From: DC Scanning  
 To: DC Support  
 Subject: NH/24/05397 24/00539/F Land To The East Of Stratfield Brake And West Of Oxford Parkway Railway Station, Oxford Road, Kidlington  
 Date: 28 May 2024 16:19:00

**Proposal:** Erection of a stadium (Use Class F2) with flexible commercial and community facilities and uses including for conferences, exhibitions, education, and other events, club shop, public restaurant, bar, health and wellbeing facility/clinic, and gym (Use Class E/Sui Generis), hotel (Use Class C1), external concourse/fan-zone, car and cycle parking, access and highway works, utilities, public realm, landscaping and all associated and ancillary works and structures.

**Application Number:** 24/00539/F

**Our Reference:** NH/24/05397

Figure 4.1: OUFC VISSIM Model Extents

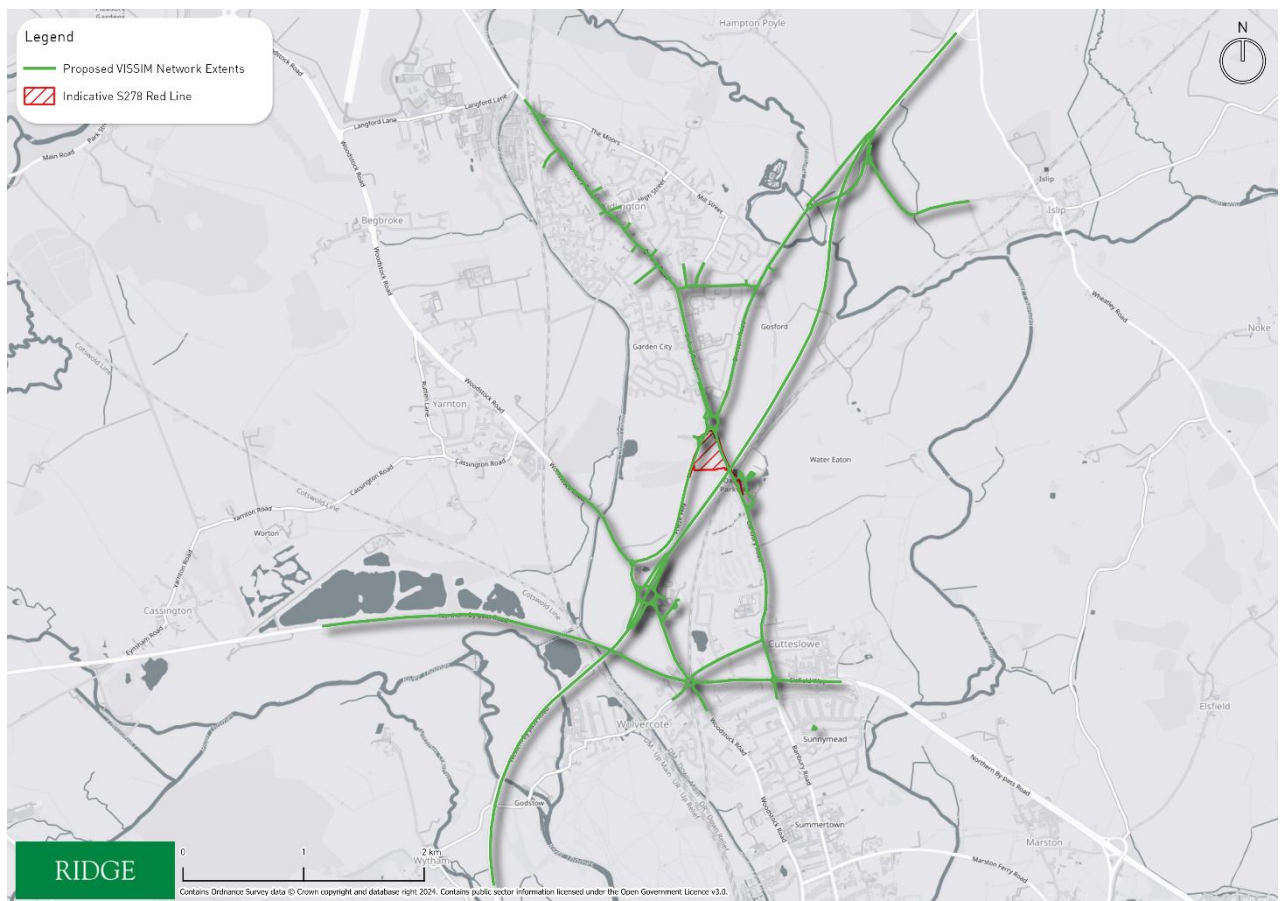
Table 2.1	NA	4	An additional column representing the '2018 BASE YEAR' models should be added to Table 2.1 for clarity.
VISSIM modelling	4	4.1.3 & Figure 4.1	The highway network will be amended, this will include the cordoning of the existing network to the extents shown in Figure 4.1.	6	The model cordoning (and extension) proposal appears reasonable. However, the amounts of traffic not loading onto the VISSIM network should be monitored and tracked if queue lengths exceed available highway queue storage.
